**Re: Permit #** SHL18-017  
**Project Name** Fallquist Community Dock  
**Project Address** 5067 84<sup>th</sup> Ave SE (parcel # 407600-0800)  
**Reviewer** Nicole Guadette, Senior Planner  
**Department** Planning & Development

Below are our responses to the corrections in your letter dated April 27, 2020. Your original comments are in **bold italics** followed by our response in plain text.

# PLANTING PLAN

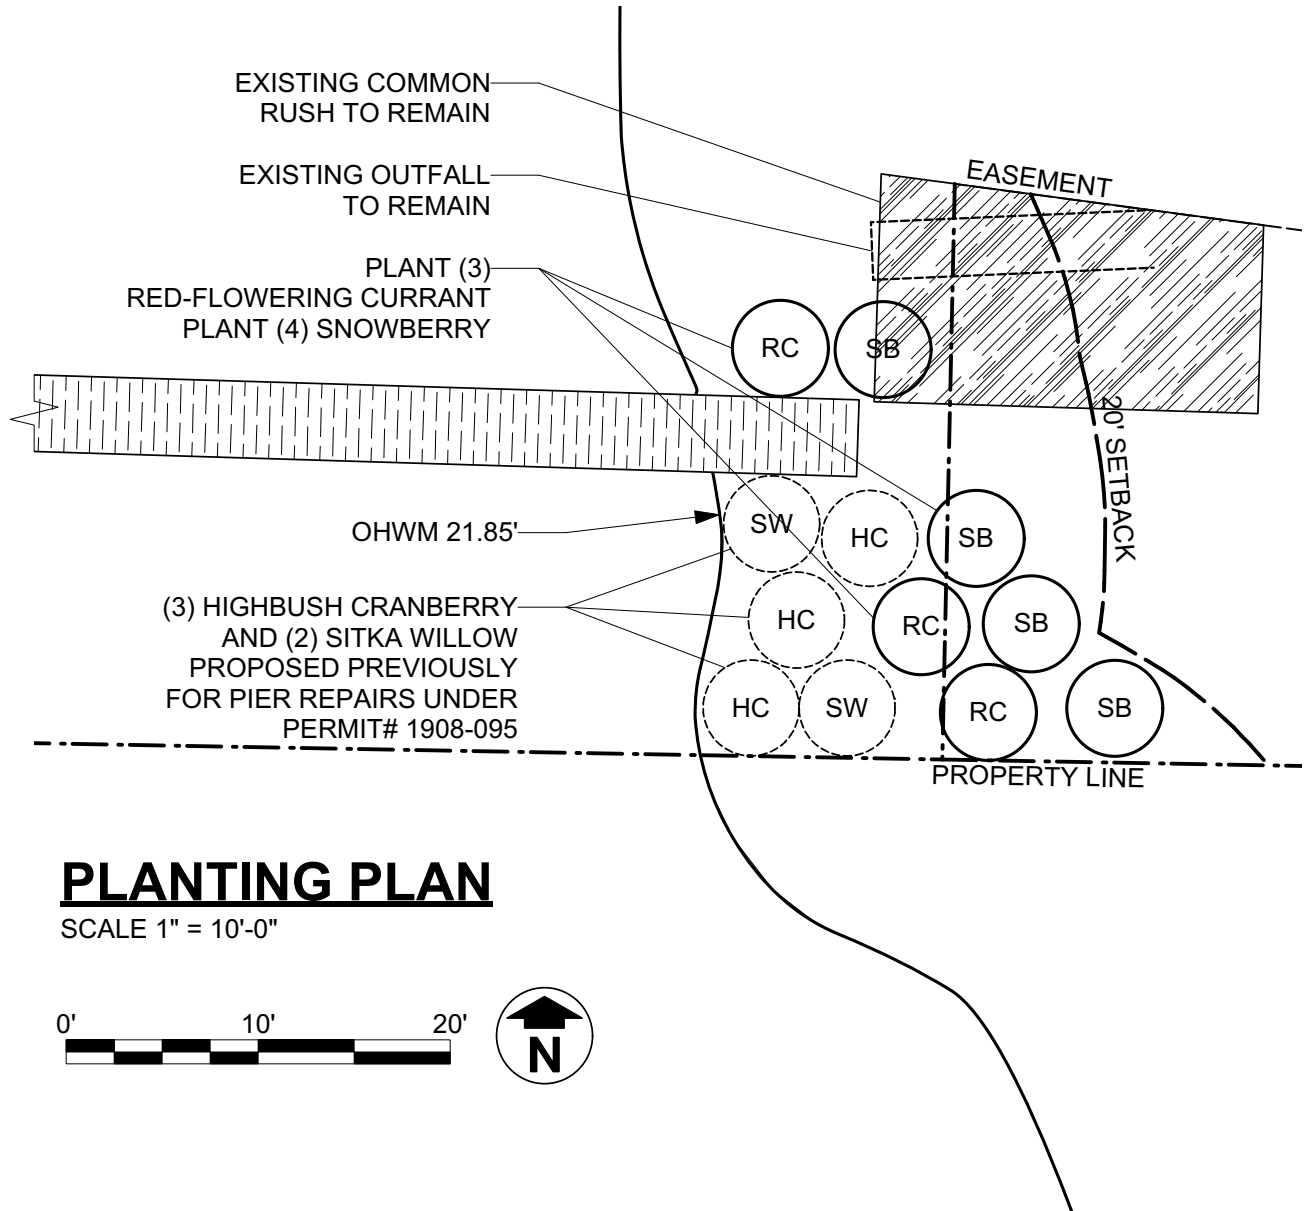
**Plantings in addition to those mitigating the repairs authorized via permit #1908-095 will be required to mitigate the impacts of the dock extension.**

In addition to the plantings authorized via permit #1908-95, seven native shrubs will be planted for the project. The shrubs will be less than 8 feet in height as required by the settlement agreement. The planting plan on sheet 7 of the drawings has been revised with these plantings.
